REVISED ADDENDUM RESPONSE TO SUBMISSIONS AND UPDATED AMENDED PROJECT REPORT

**QANTAS FLIGHT
TRAINING CENTRE
SSD_10154**

- Project Site Boundary
- Extent of Works
- +RL 0.00 Proposed nominal design levels (Refer Civil)
- +EX 0.00 Existing level
- Existing 0.1m contour

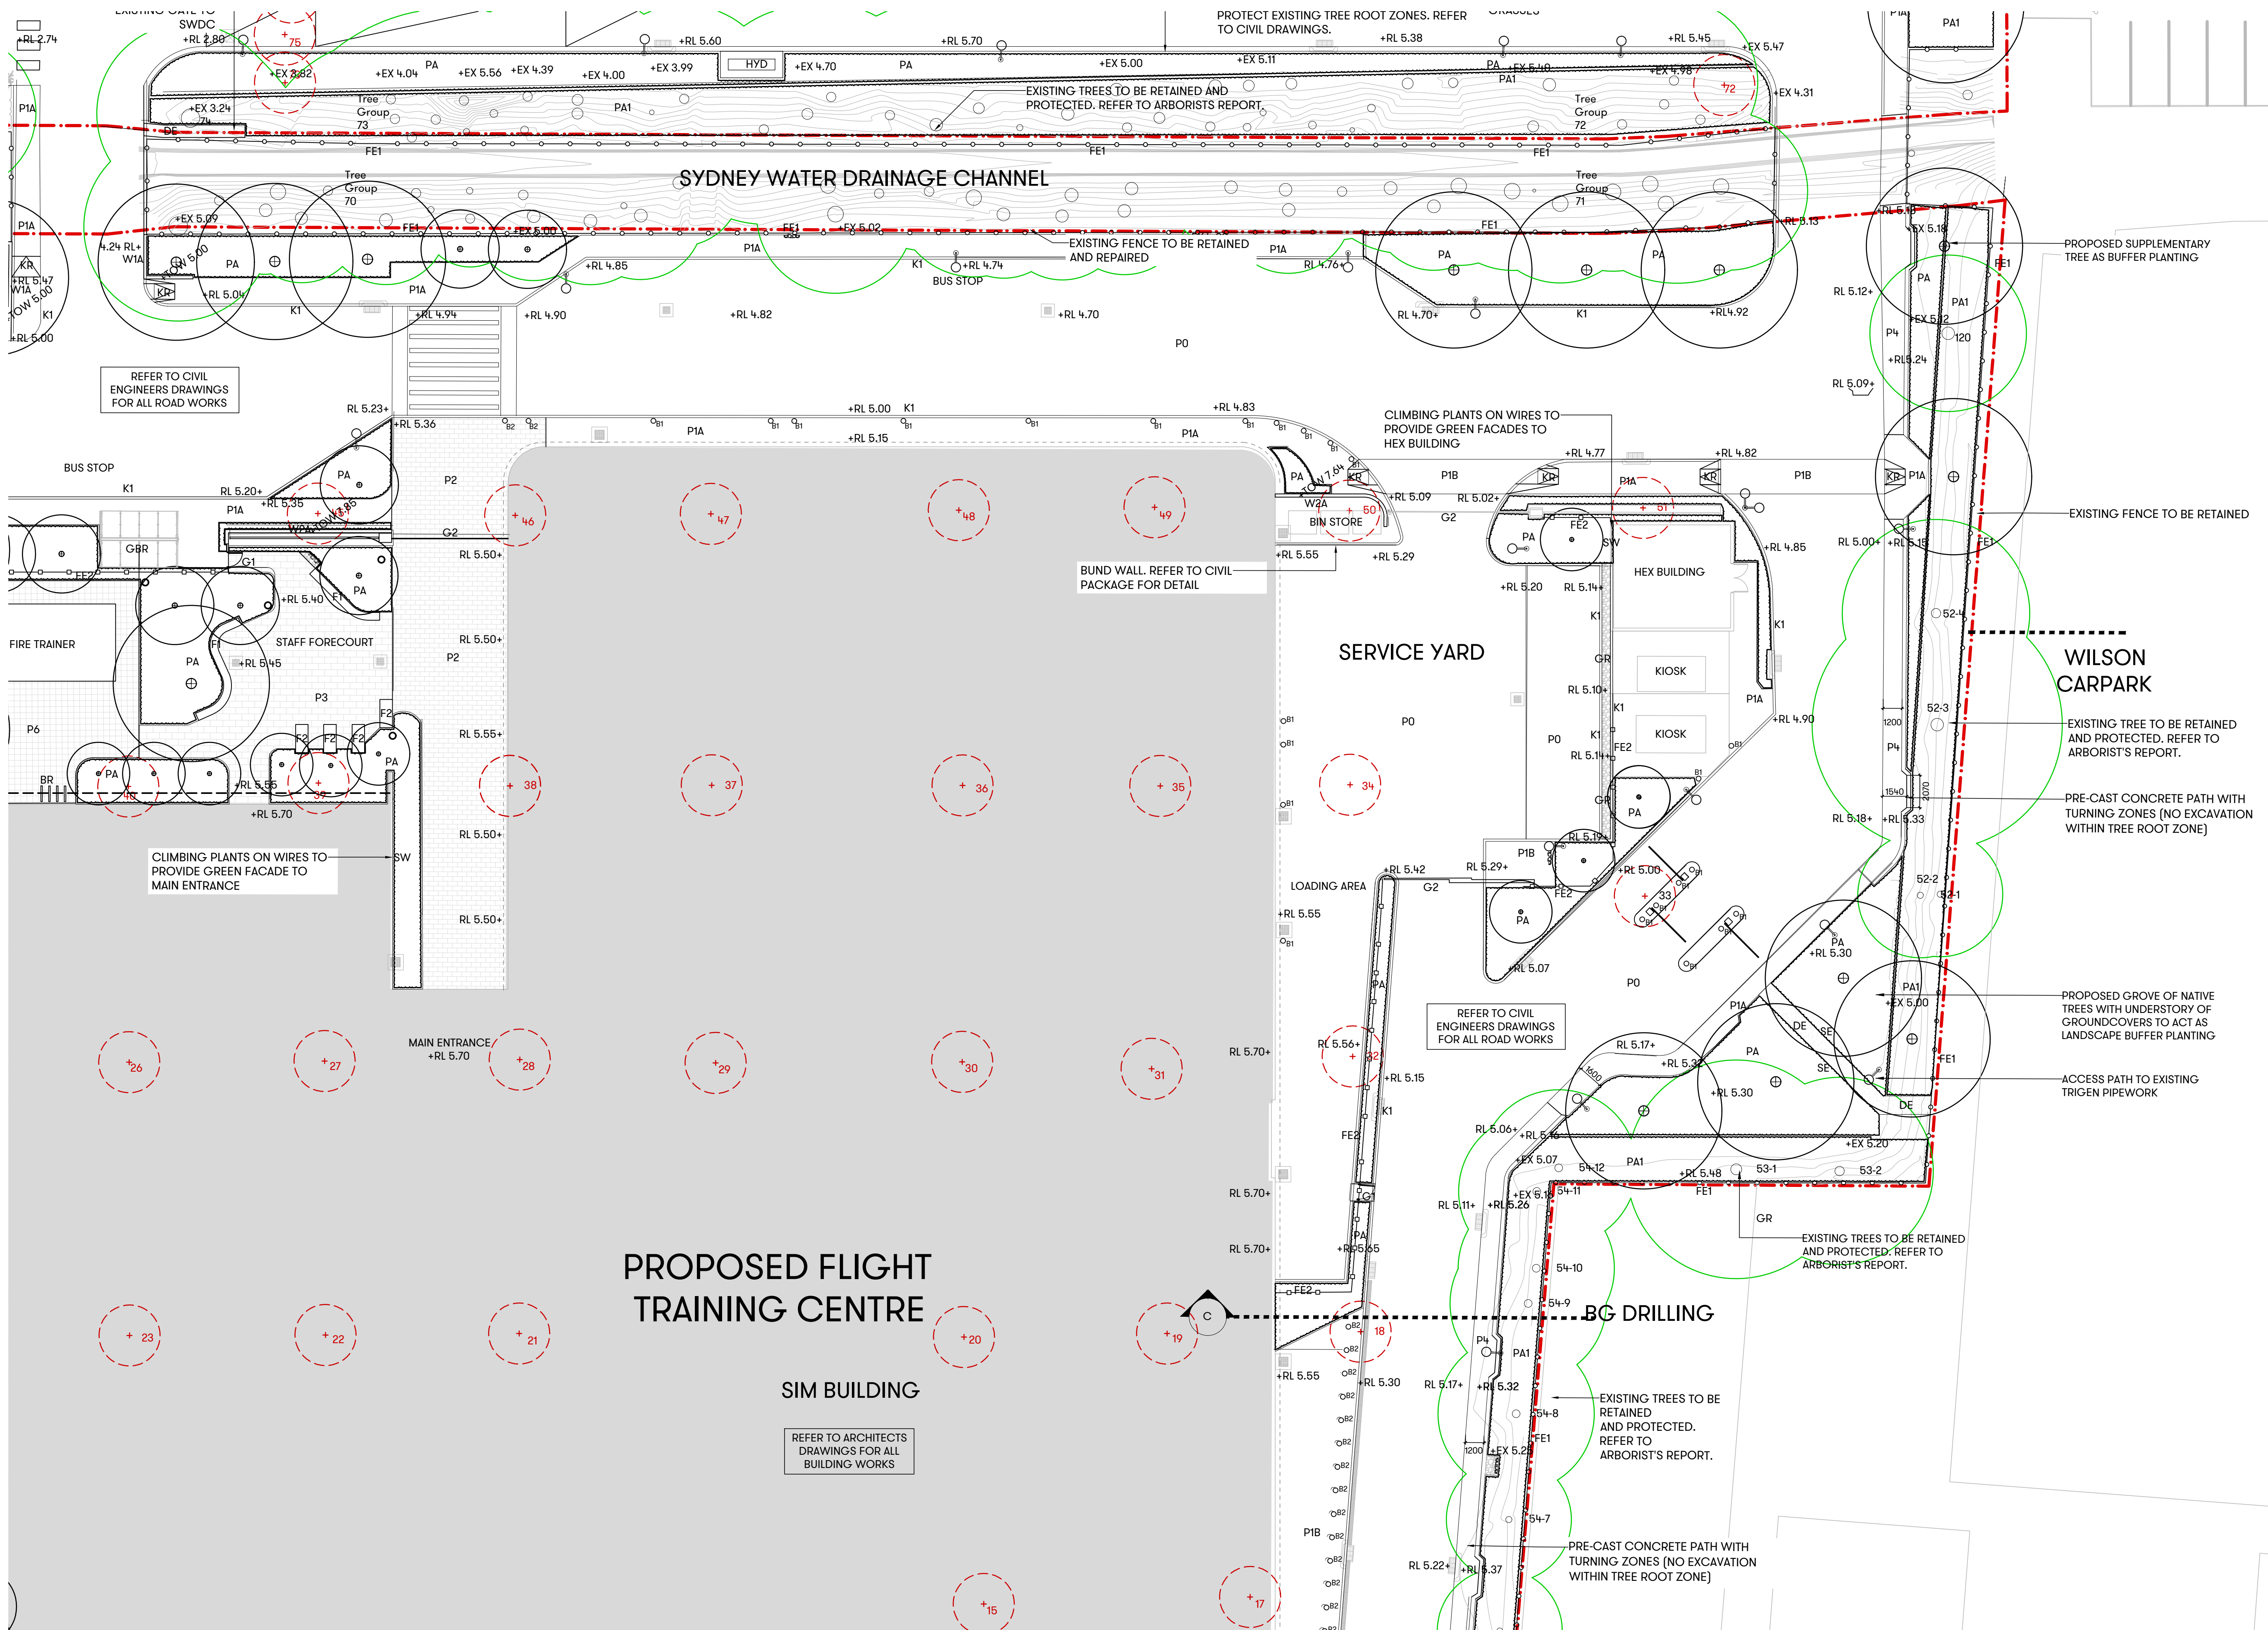
Landscape Architecture	<p>The amendments made to the proposal are supported subject to the inclusion of various conditions being included in the determination:</p> <p>1) The Final Landscape Plan shall be generally in accordance with the Landscape Plan prepared by Scott Carver, revision 2, dated 31st July 2019 and comprise detailed landscape construction documentation (plans and specifications) to be submitted to, and approved by Bayside Council's Landscape Architect the Principal Certifying Authority prior to the issue of the</p>	<p>The proposal for planters across the carpark facade currently are not intended to support trees. The proposal shows planters suitable for a mix of shrubs, groundcovers & climbing plants.</p> <p>The proposal includes irrigation connected to the rainwater tank to all proposed soft landscape in the King Street North but the carpark soft landscaping will be irrigated from potable water.</p>

<p>Construction Certificate. The landscape documentation shall include, but not be limited to:</p> <p>a) Planting plan at 1:100 showing all plant locations/ groupings and plant centres/ species. There is to be a dense layered planting scheme consisting of trees, shrubs and groundcovers in all of these areas.</p> <p>b) Construction Details of the proposed 21 façade planters that work as green walls and the bus shelter green roof, including details of planting; and a 12 months maintenance schedule of these elements.</p> <p>c) Elevated planter box sectional details and drainage details. All planter box depths and dimensions shall be in accordance with Council's DCP and capable of supporting medium and large trees a mix of shrubs, groundcovers & climbing plants.</p> <p>d) Specifications detailing soil and mulch finishes, root barriers, irrigation, edging and other landscape works such as retaining walls, steps, planter walls, feature walls, skateboard restrictions, tree pits, tree grates, tree guards, tree pit treatments.</p> <p>e) Construction/ section details for areas of paving, edge treatments, and tactile areas including a schedule of materials.</p> <p>f) Details of all fencing, privacy screening, arbors and the like, including elevations and materials visible to public domain areas.</p> <p>g) Details of all other hardscape landscape elements such as street furniture, pedestrian amenity lighting, bins, bollards, as required. Locations are to be clearly identified on plan. Sectional construction details and elevations to be provided.</p> <p>h) A Landscape Maintenance Schedule shall be submitted that covers a 12 month period to provide a guide to the landowner or occupier on how to best maintain the constructed landscaped areas; and is to include the following information:</p>	<p>Therefore, it is requested that the recommended condition is updated to reflect the above – amended condition in (red).</p>
